January 4, 2024

**Re: Montage 5 at University Blvd and Bobby Foster Rd
Erosion and Sediment Control Plan
Engineer's Stamp Date 12/21/23 (R16E006C)**

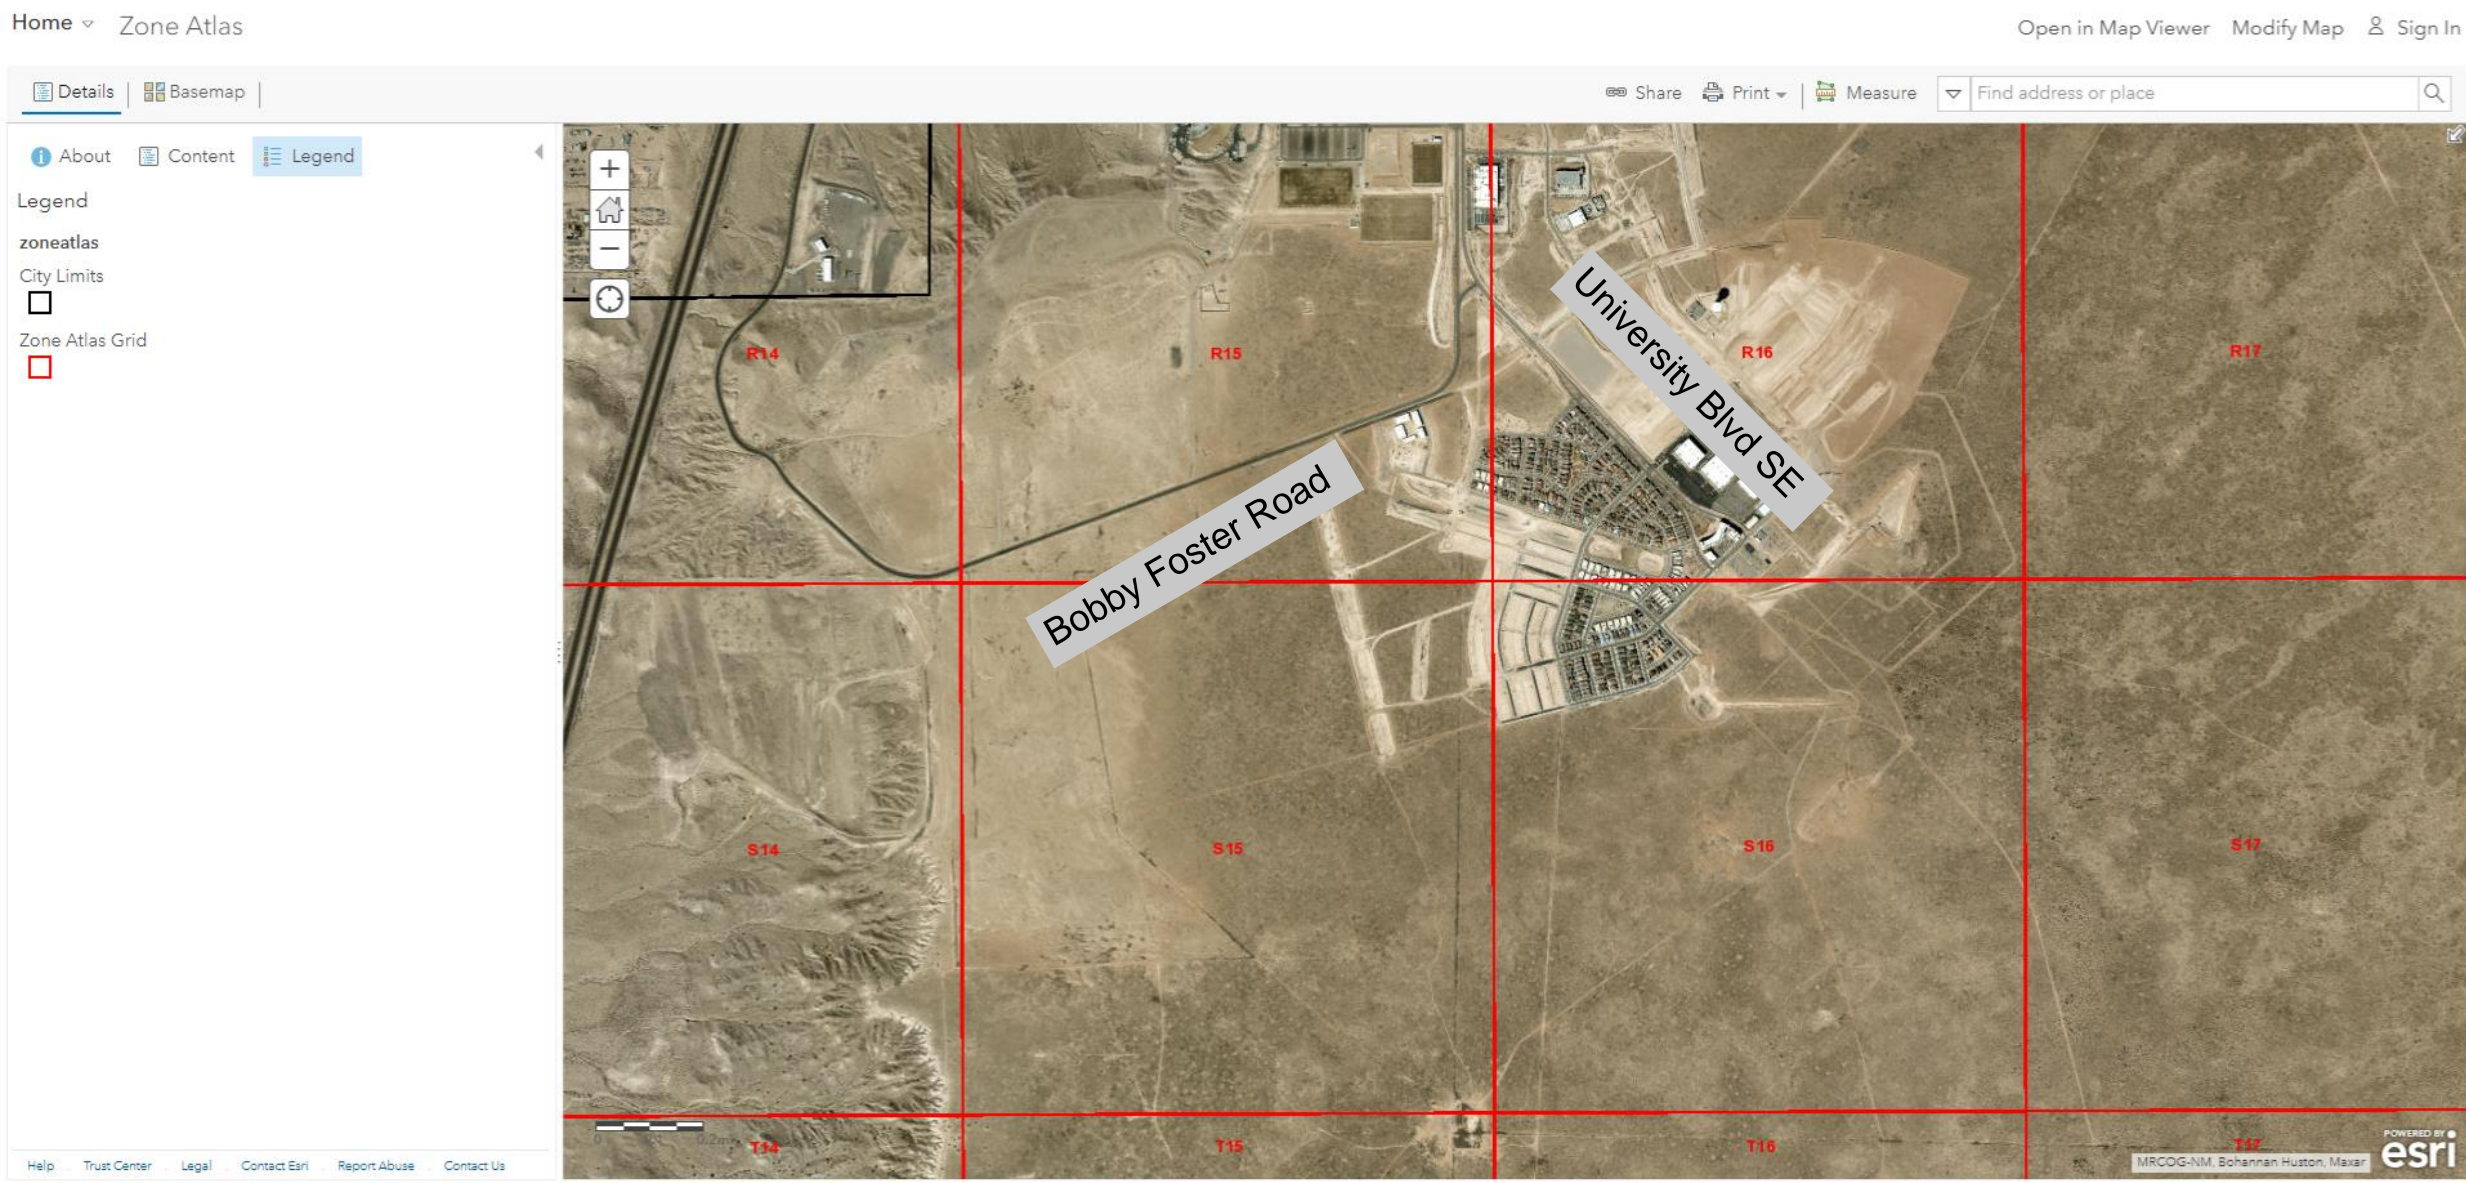
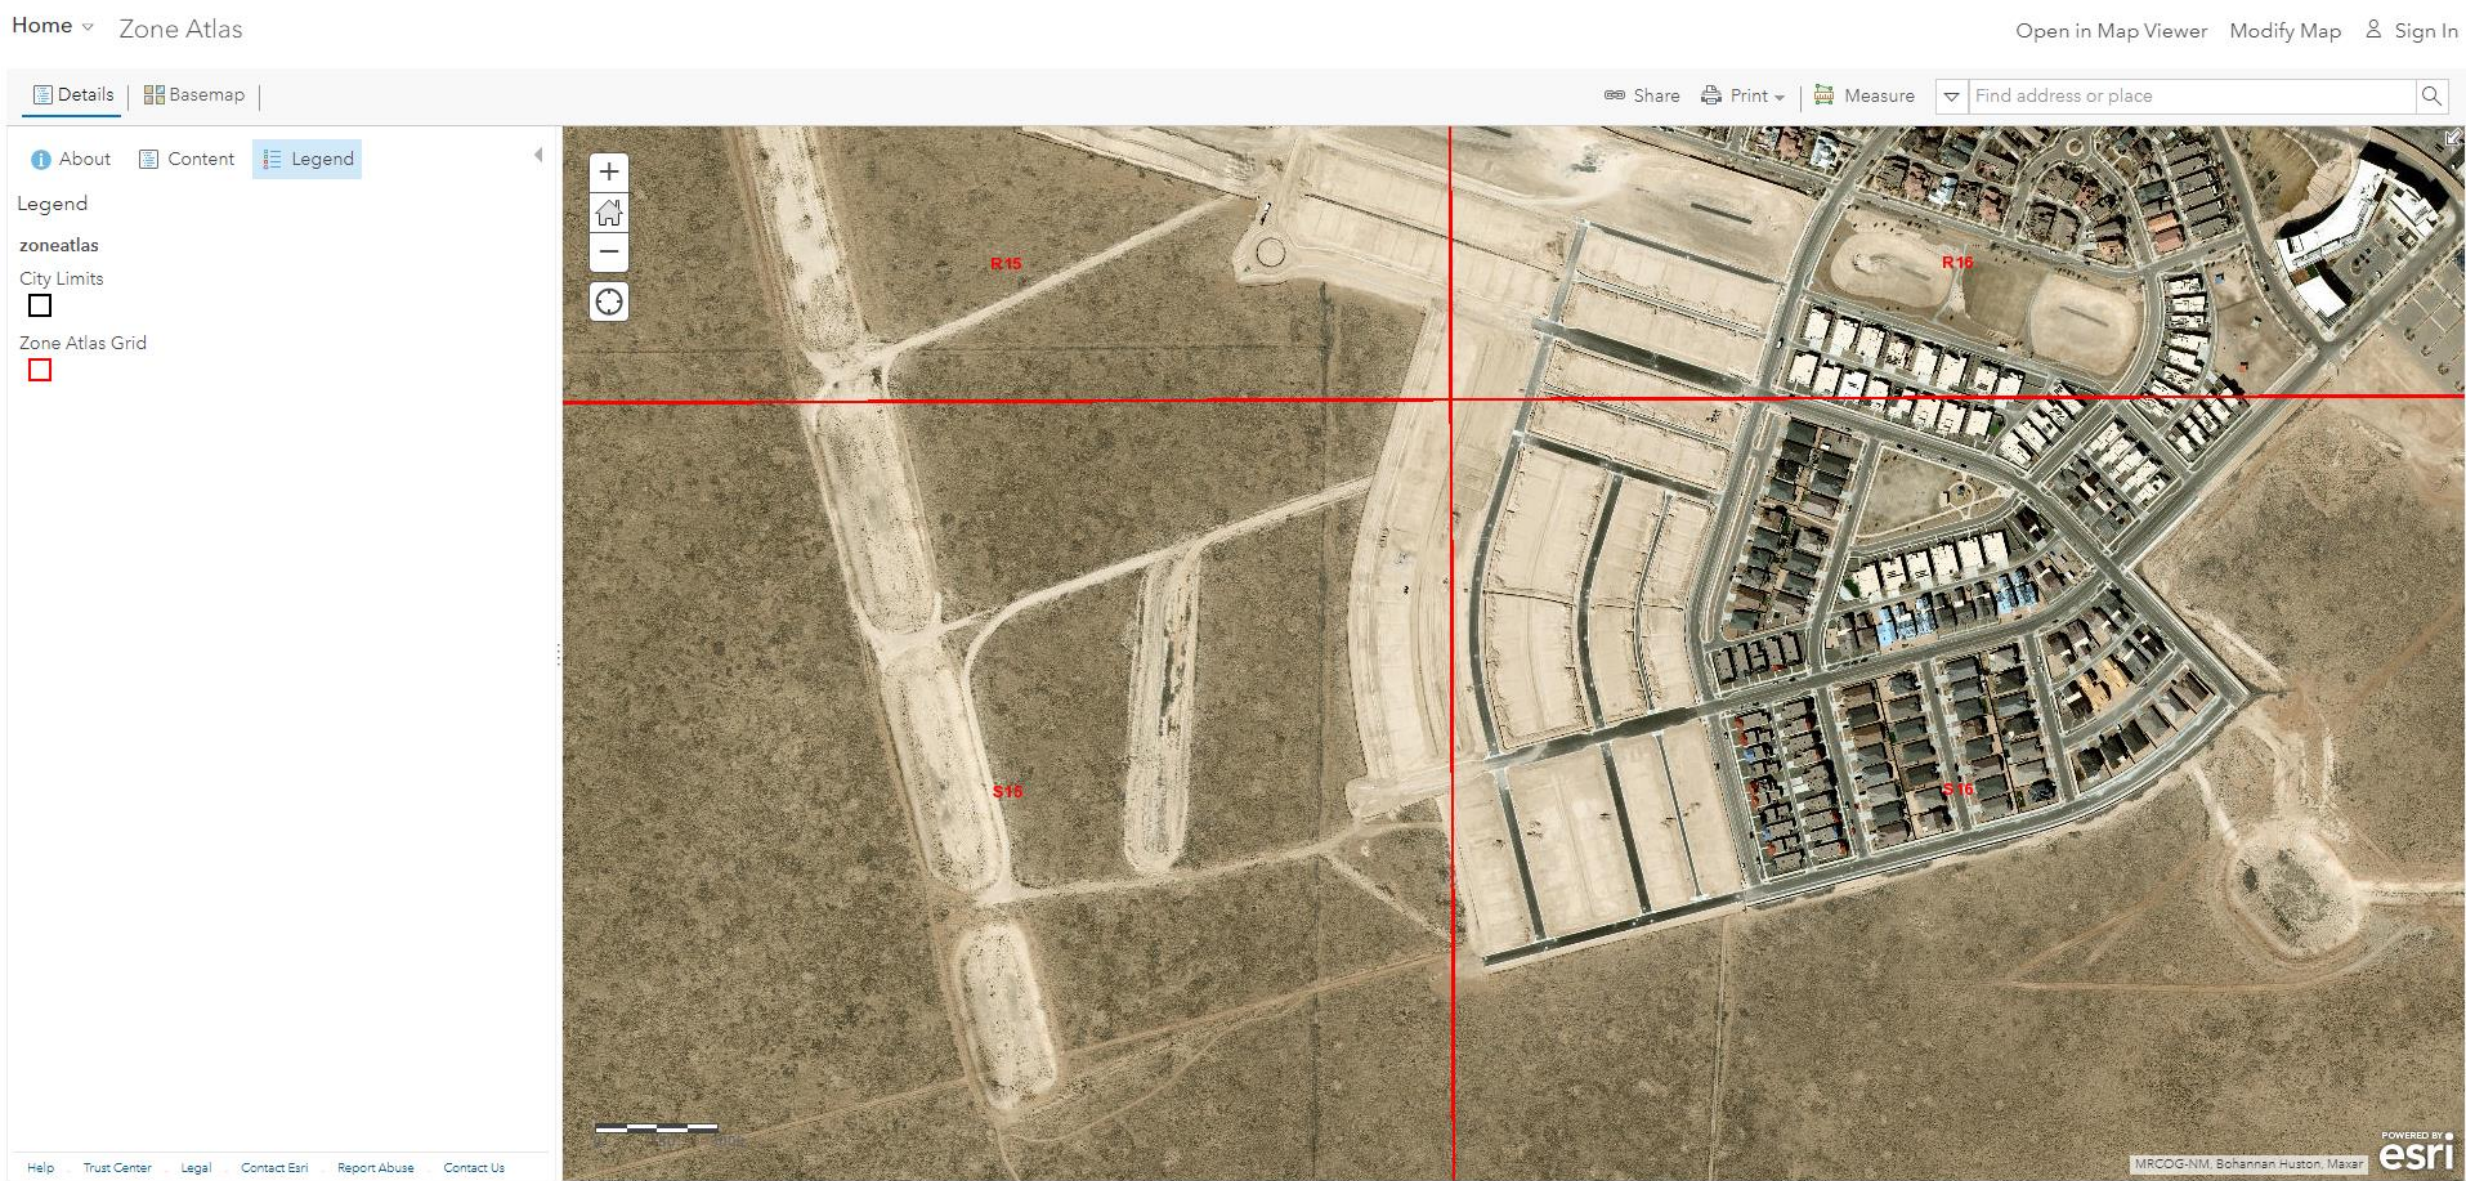
1. There were no track-out controls noted on the ESC Plan Map. Identify or note the location of the track-out controls on the map.
2. The designed ponds are on a property owned by another entity, MDS Investments LLC. The approximately 8 acres would require permit coverage under their name.
3. Update the engineer's stamp date each time the plan is changed.
